From: Thomas Callaway
Sent: 22 October 2014 13:36
To: Planning.Responses
Subject: RE: Planning Consultation on BE/121/14/DOC

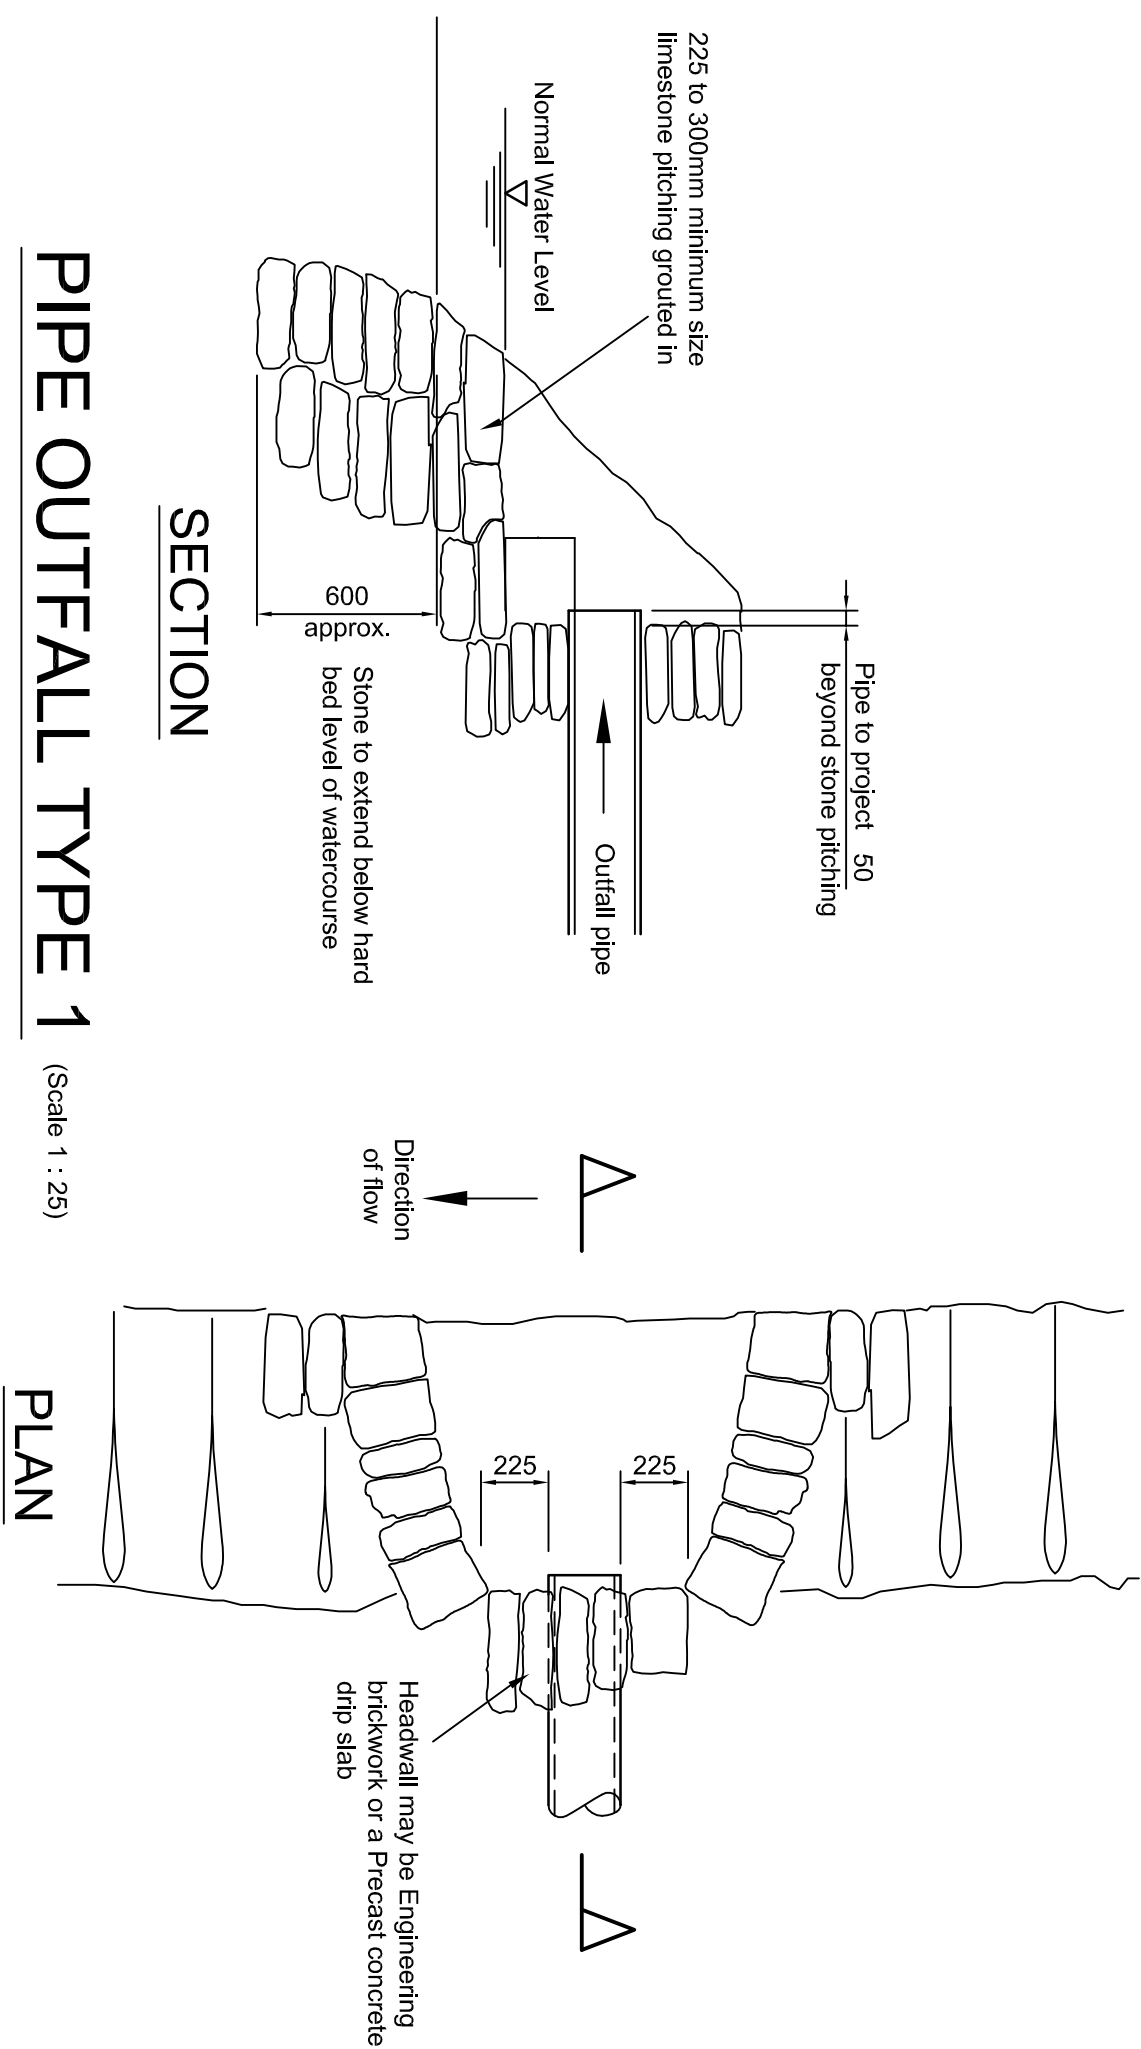
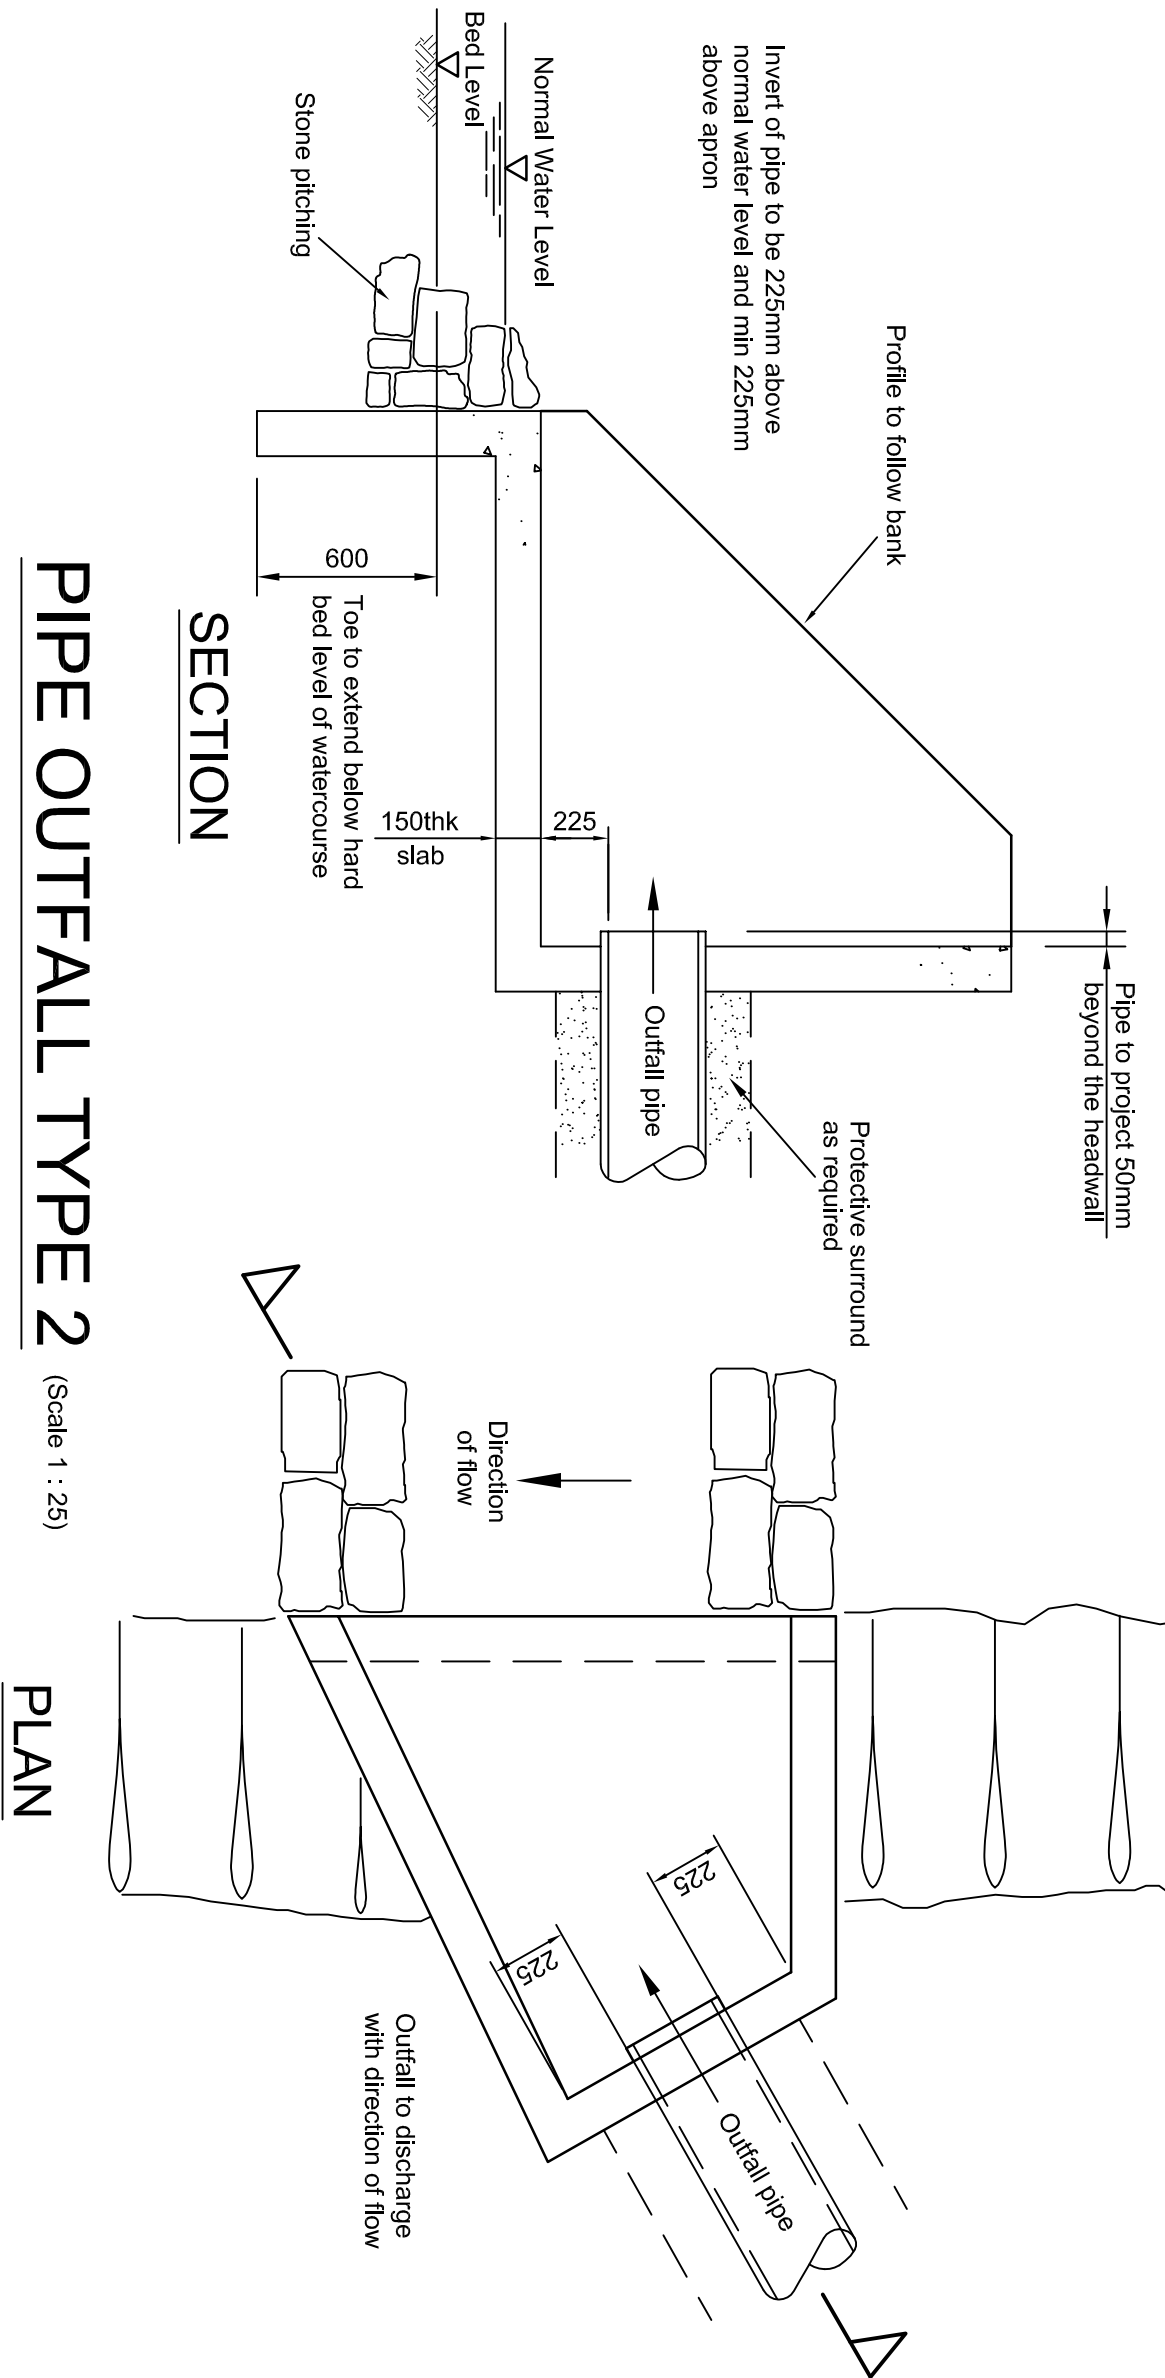
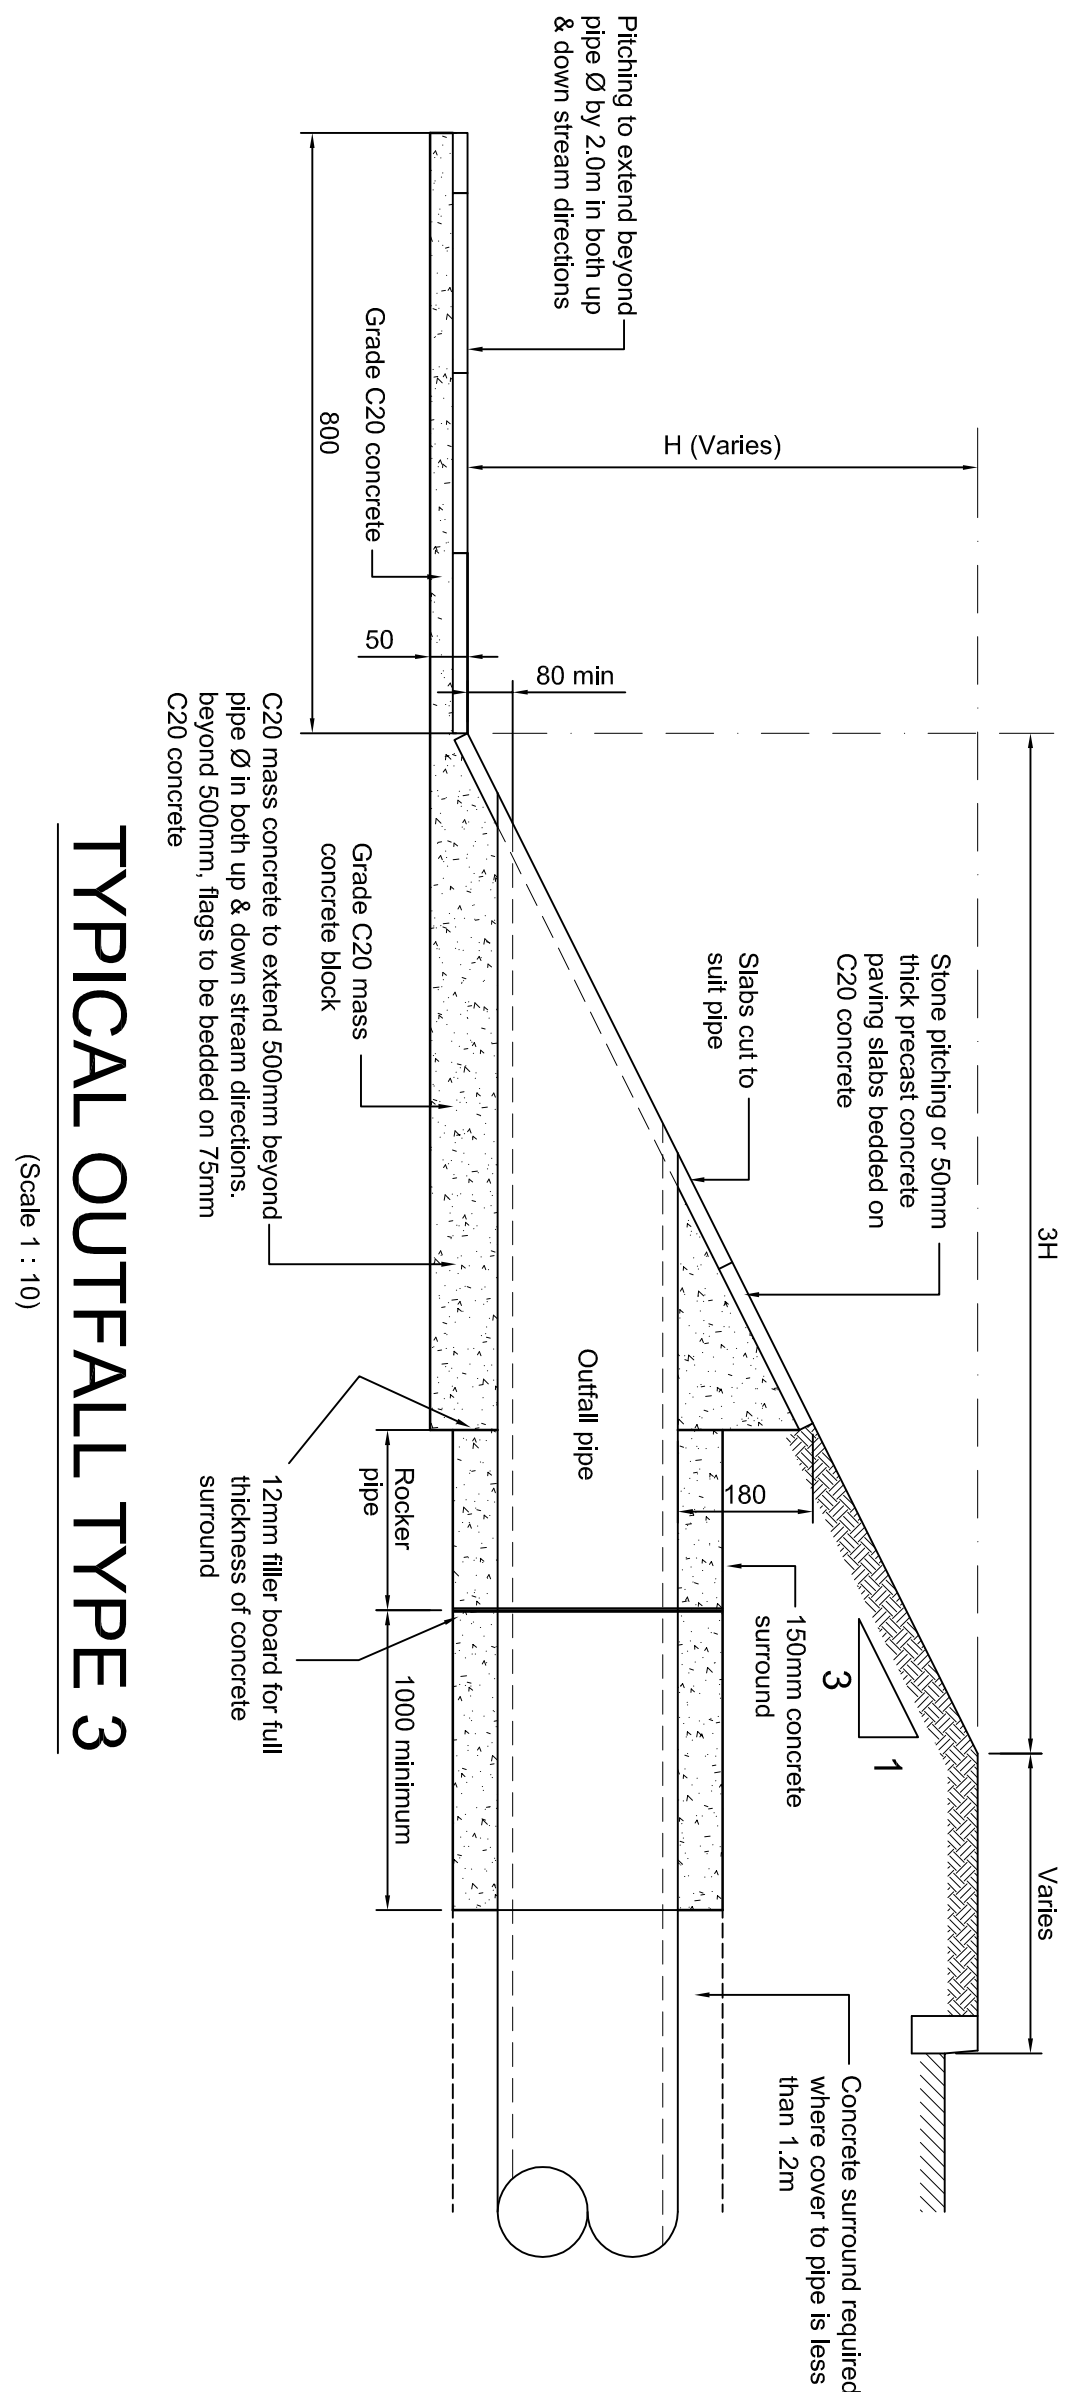
If the pond is to remain, the outlet should be more angled in line with the flow in the ditch it is discharging to. Construction drawings are still required to show the outlet, flow control and how the pond liner is to resist floating when groundwater is high (ensuring the design storage is retained).

PLAN ON ATTENUATION POND  
Scale 1: 500

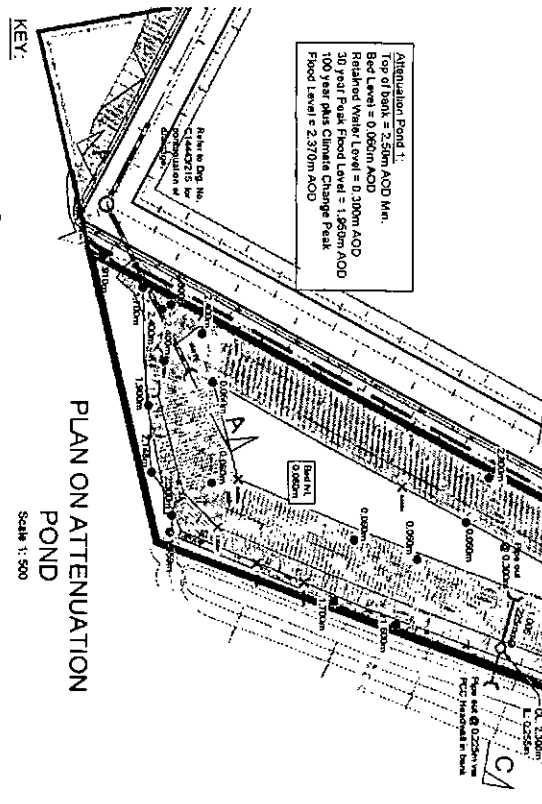
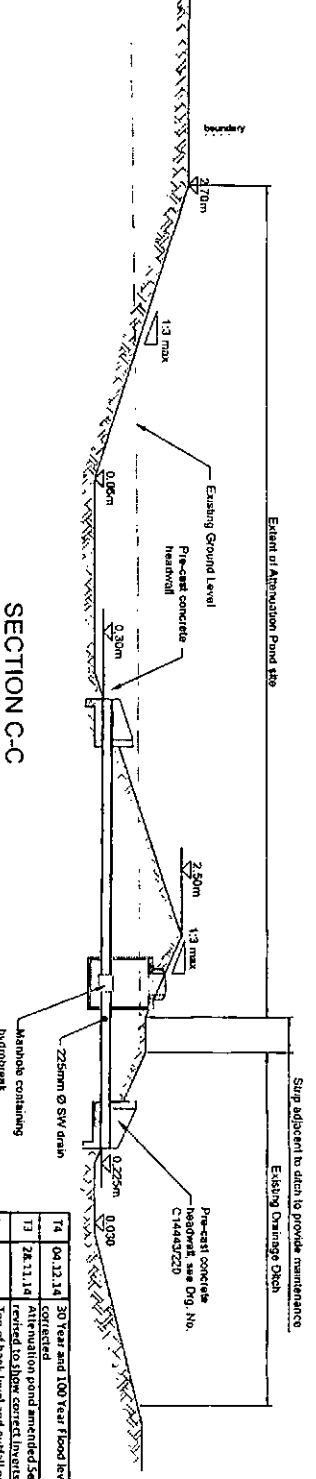
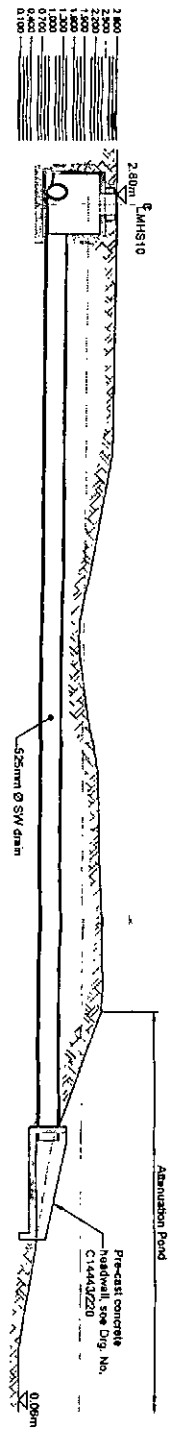
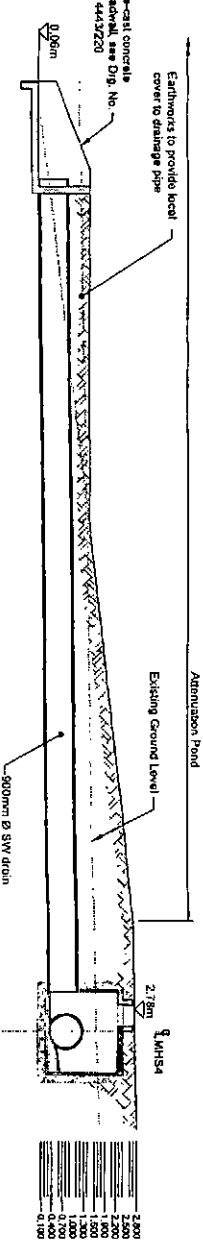
The pond is in a cramped position and the freeboard for a 1 in 100 year storm event plus climate change is only 50mm. There should be a minimum freeboard of 300mm, and also there should be a 3 metre accessible easement between the pond and railway ditch for maintenance of both features. If permeable paving is incorporated, less storage will be required in the pond and ponding issues in the car park for extreme events will be reduced.
